Re: 2nd Site Development Plan Review, King Soopers #147 – Falcon Market Place

Please find below our re-submittal package addressing the comments received on May 4, 2020. To facilitate your review, we have included the original comments in italicized font, and have provided our responses in [blue](#).

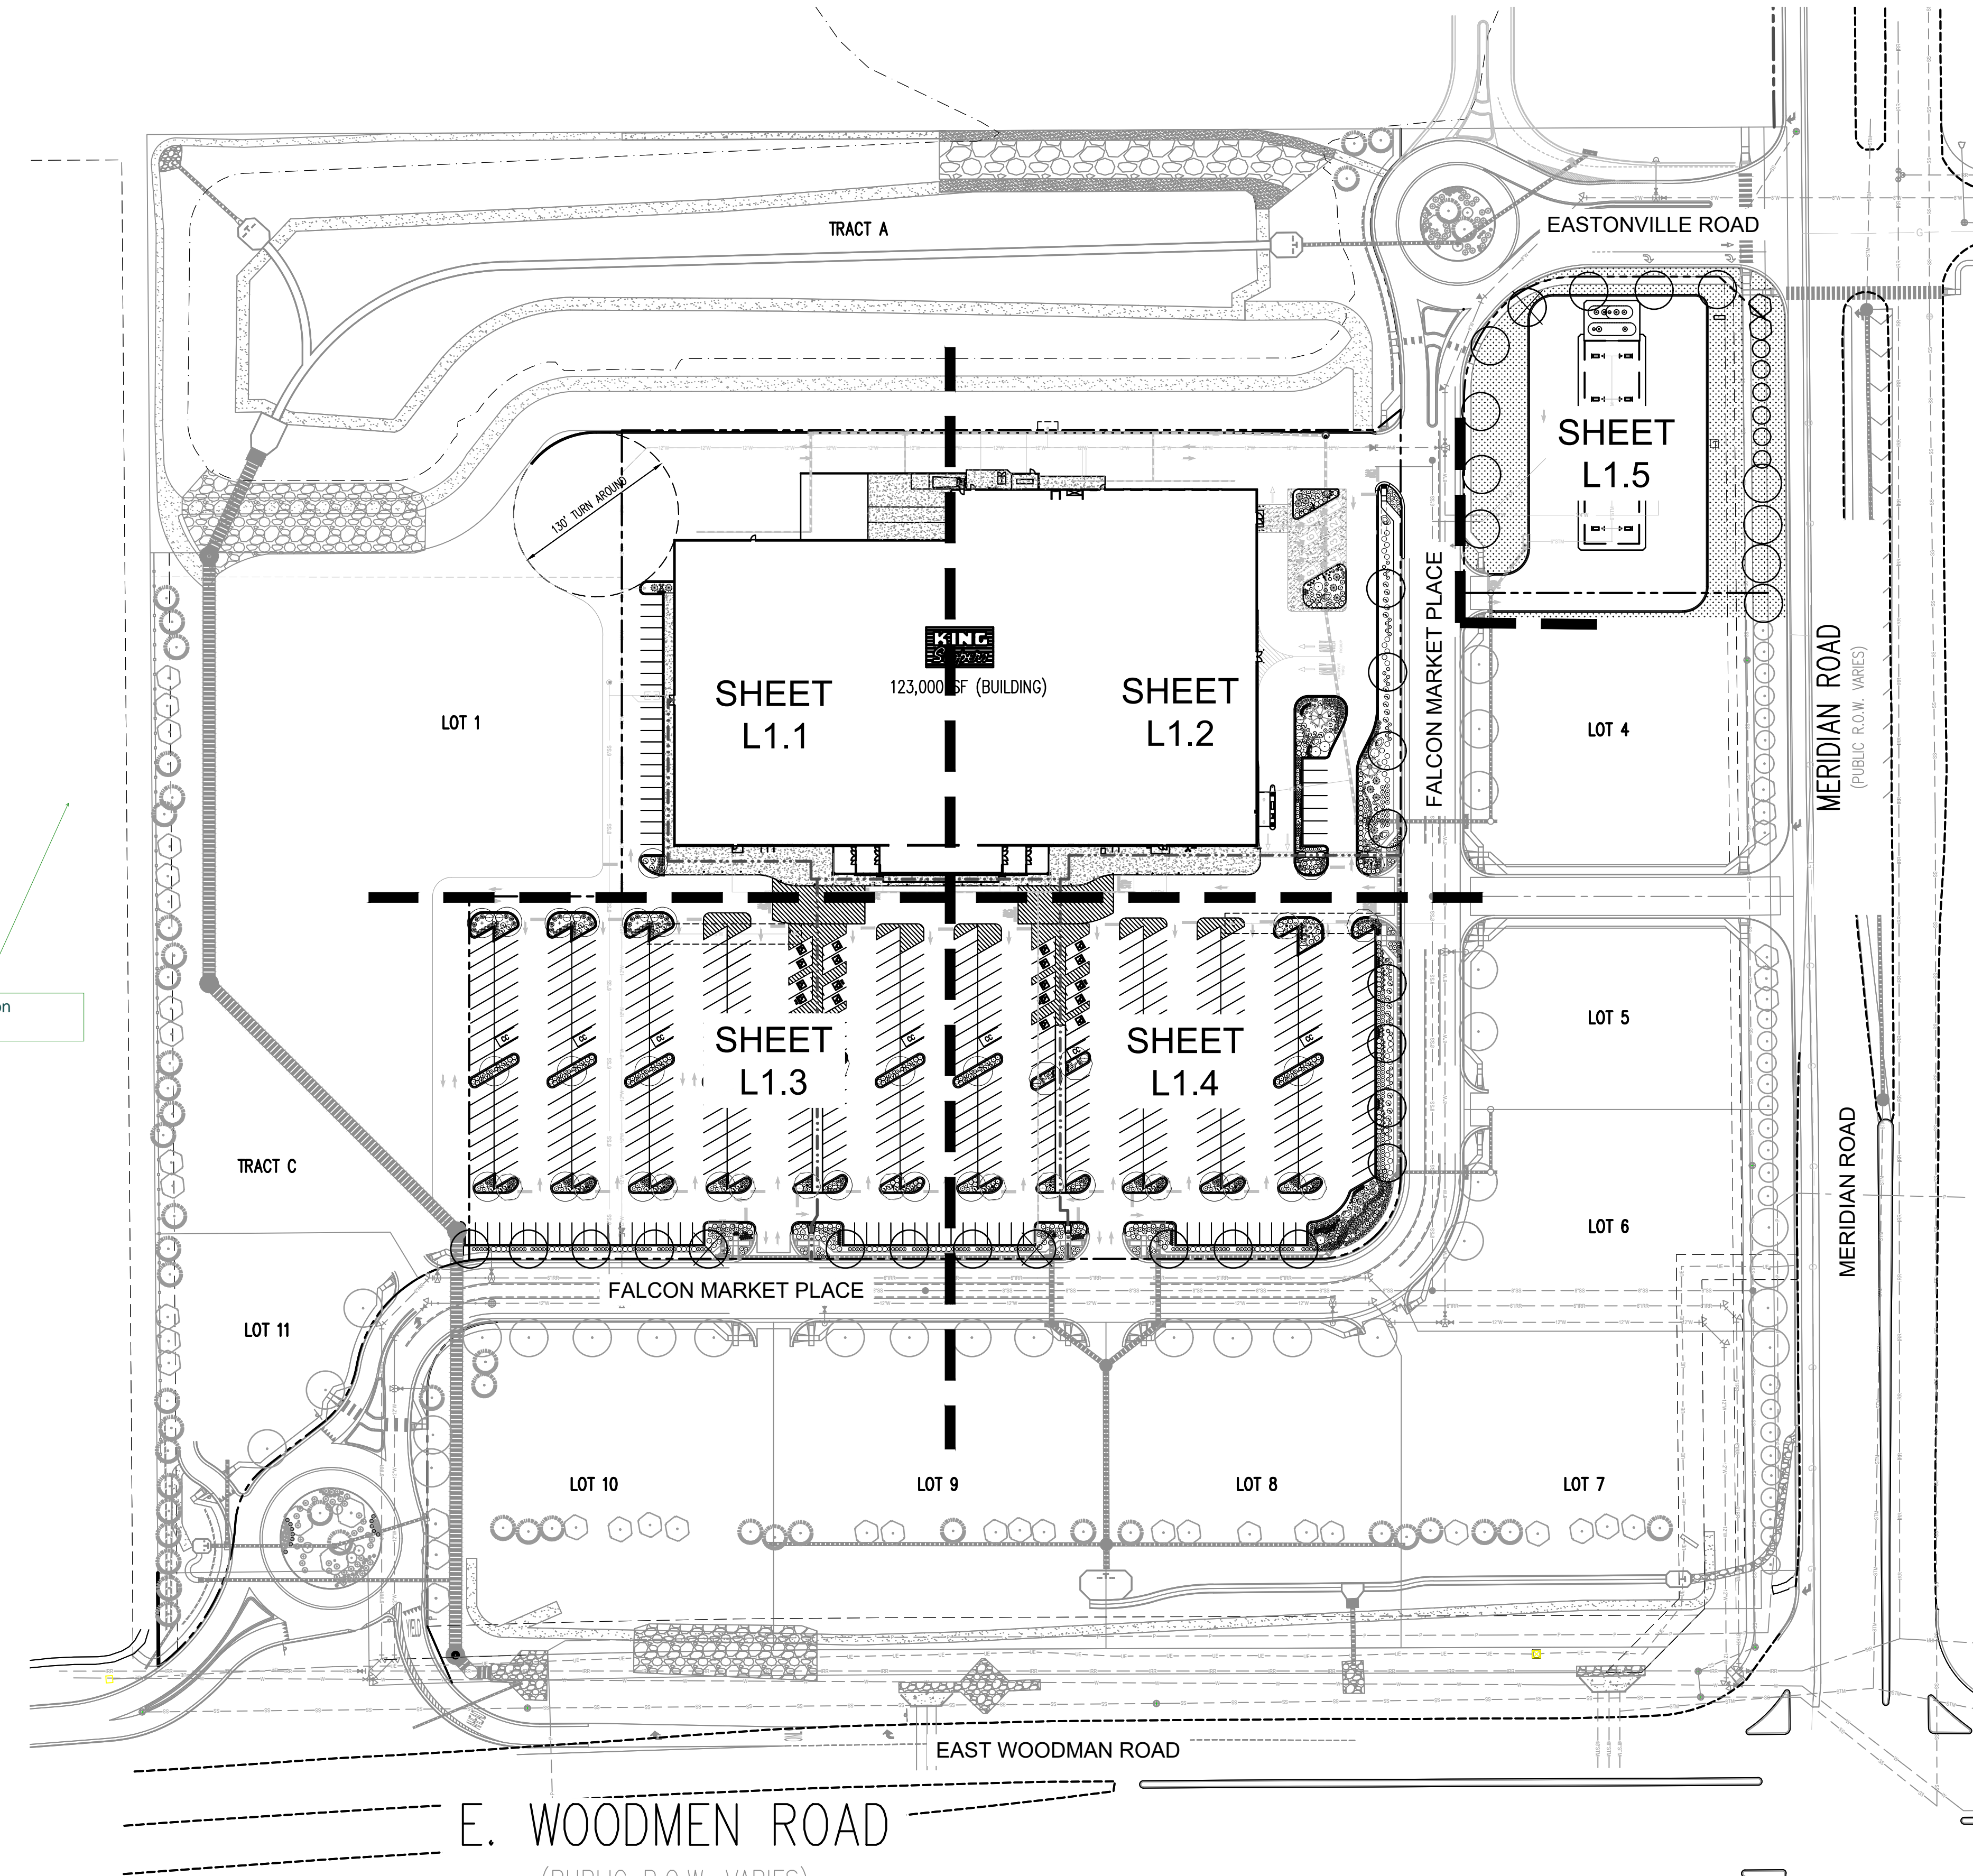
✓ Please ensure consistency with approved landscape plan for Falcon Marketplace plan. Several locations appear inconsistent / deficient with the number of street trees proposed.

Galloway Response: Per conversation with Ryan Howser on 5/21, the number of street trees currently proposed matches the approved plan. This comment can be disregarded.
